Project: ScottishPower Renewables East Anglia ONE North and East Anglia TWO Offshore Wind Farms Grid Connection Review

Date  
16/11/2020

## ScottishPower Renewables East Anglia ONE North and East Anglia TWO Offshore Wind Farms Grid Connection Review

Plate 3.1: HVAC 190x190m substation model for 800MW

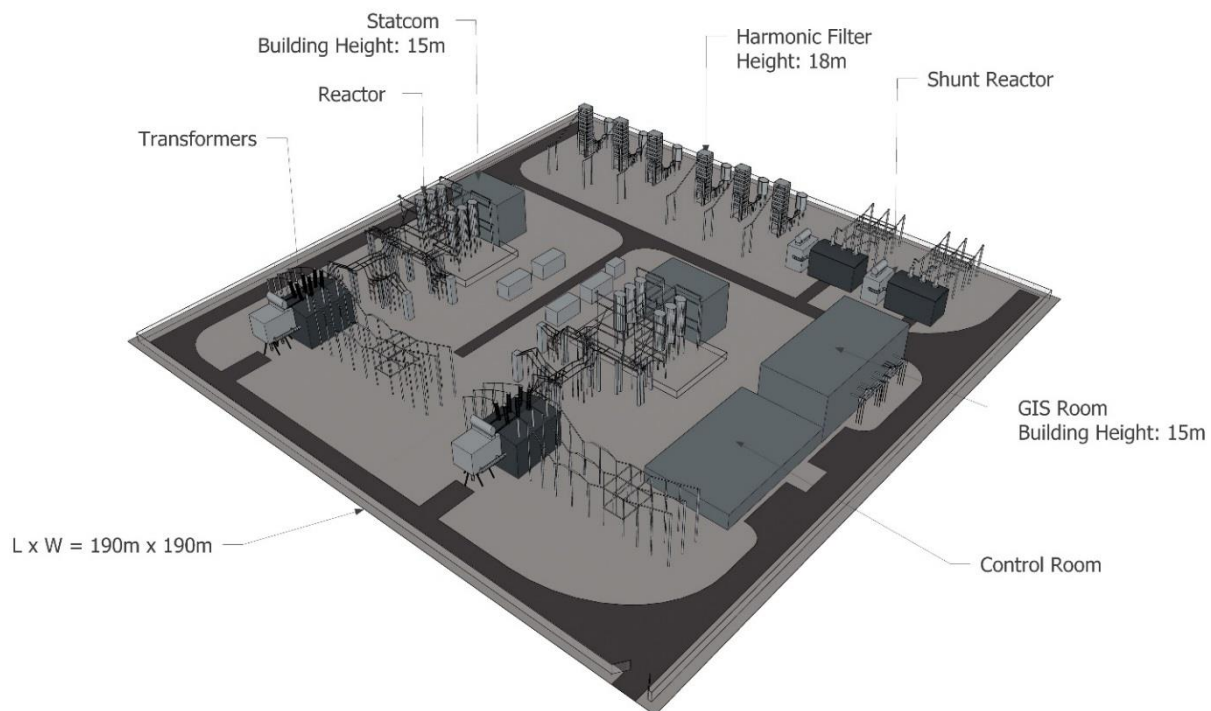
The layout proposed for each wind farm-receiving substation is 190 m x 190 m. The technology shown for the EHV switchgear is GIS; no voltage level is given but we expect that it will either be 220 kV, the same voltage level as EA1, or 275 kV.

The substations each have their own GIS and Control Buildings and there is potential for saving in land area if the two are combined. Based on the layout provided and the single line diagram for EA1, saving in land area will be relatively modest.

road suggesting a possible location for AIS 220 kV switchgear instead of the GIS switchgear shown towards the bottom. The control building does seem to be rather large (13 x 40 m) but perhaps accommodates office, messing, etc. and suggests that some of the facilities could be shared between EA1N and EA2.

- 4) While there is possible scope to reduce the footprint of the two onshore substations by combining the control buildings and after consideration of the capacity/size of the primary equipment, the overall impact on the plot size is unlikely to be significant. For planning purposes, the adoption of an identical plot size to EA1 seems reasonable.

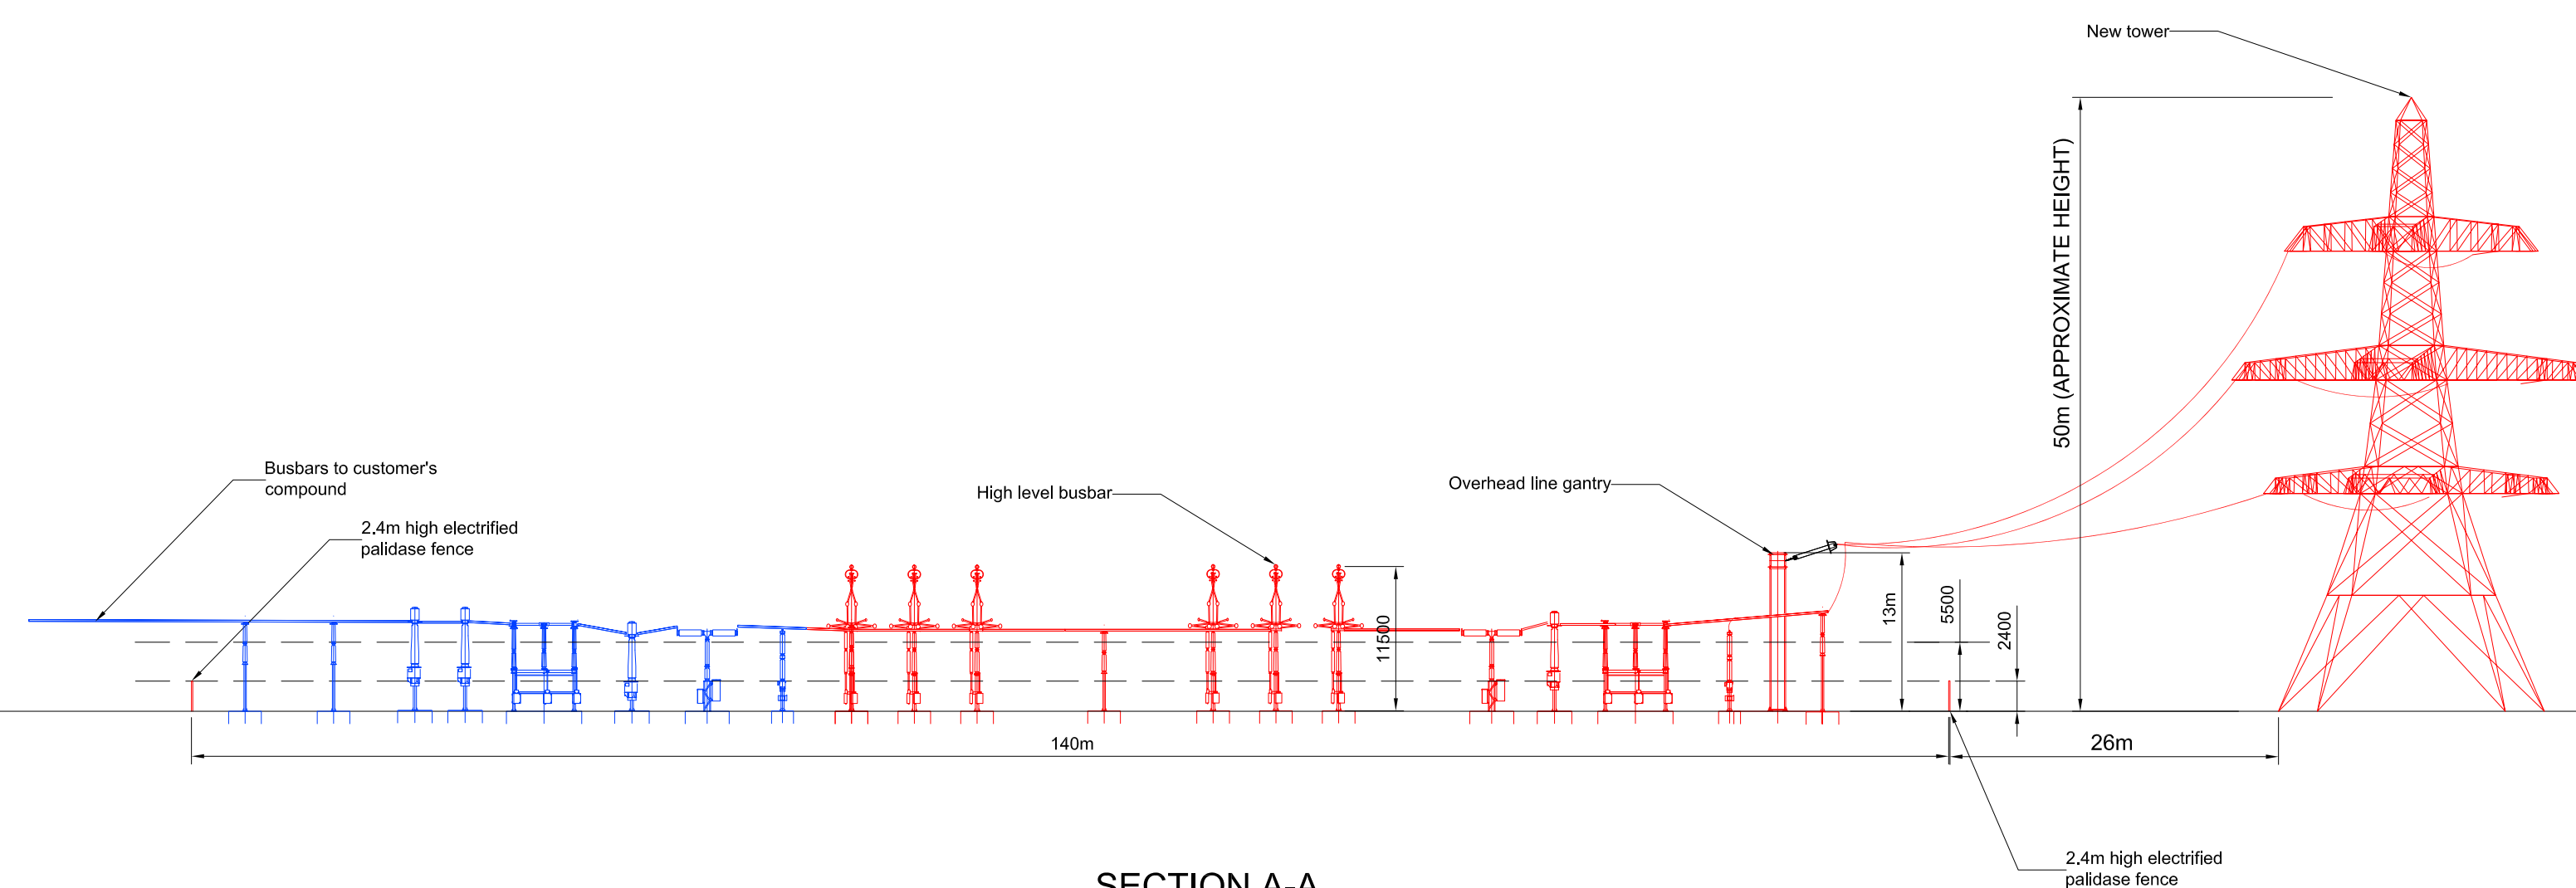
The substation footprint shown in the RAG Assessment<sup>4</sup> provided for two future customer circuits in the 325 m width. Each new AIS circuit bay occupies 21 m width.

In the Non-Technical Summary<sup>5</sup> the NG substation width has shrunk to approximately 310 m width and provision for the two future circuits has disappeared. This plot plan shows three cable sealing end compounds along the routes of the two overhead lines. It would not be possible to accommodate the two future circuits within this layout; there appears to be room to expand back to the original width or more.

Each new bay will add 21 m to the width of the 400 kV AIS substation. The original footprint of the NG substation (325 m x 140 m) had included for two future connections – these have now been removed. An additional two future bays (i.e. 4 bays in total would increase the width to 367 m which is approximately the same as the sum of the two adjacent offshore connection substations (190 x 2 = 380 m).
